CITY OF ALBUQUERQUE

September 5, 2023

Re: Enterprise/ Car Wash
5700 San Mateo Blvd. NE
30-Day Temporary Certificate of Occupancy
Transportation Development Final Inspection
Architect's Stamp dated 05-31-22 (F18-D052)
Certification dated 08-14-23

DRAWING TITLE		
TCL		
SEAL SCOTT C. ANDERSON No. 4341 5/31/2022 REGISTERED ARCHITECT	DESIGNED	PROJECT NO
	DRAWN	SCALE
	CHECKED	DRAWING NO
	REVIEWED	DATE
5/31/2022		TCL OF

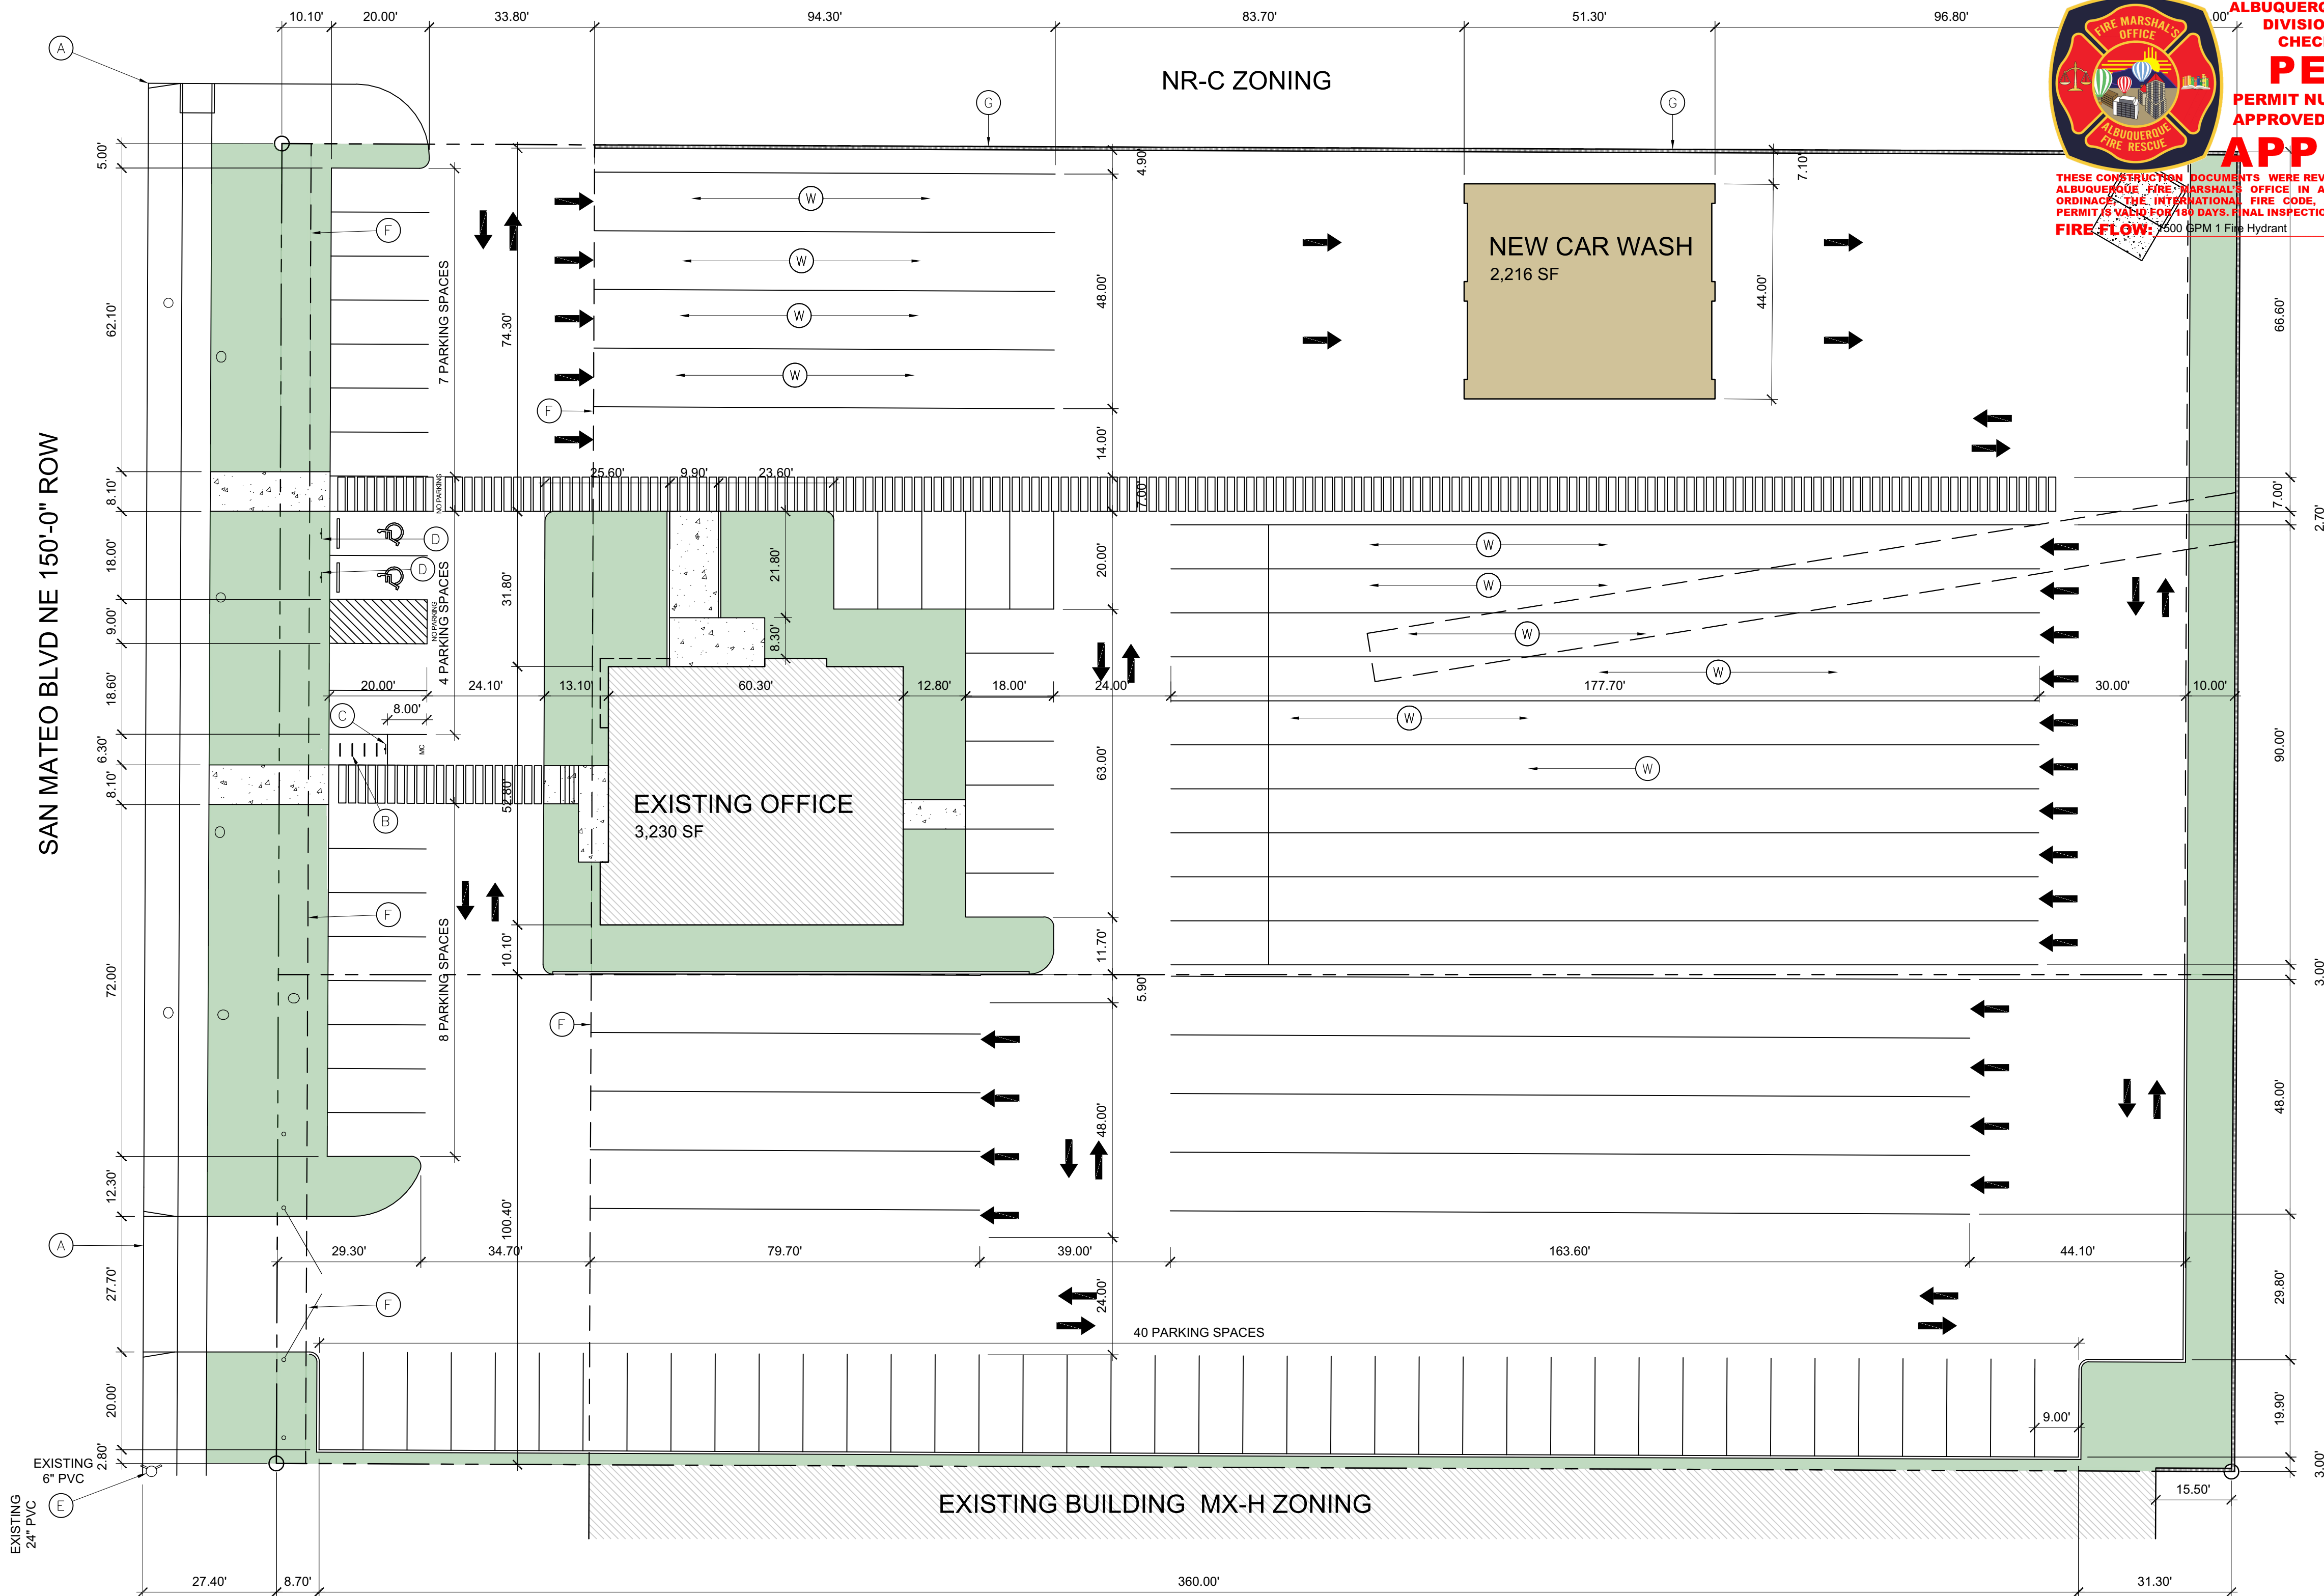
- Keynote Y: Site accesses must be built per the approved site plan.

- Minimum 6 ft. wide ADA pathway must be provided from the public sidewalk to the building entrance.
- One of the ADA parking spaces must be a Van ADA parking.

- Please anchor down the bike rack.
- Please remove these existing ADA parking spaces.

- Per approved plan, please provide Motorcycle parking space.
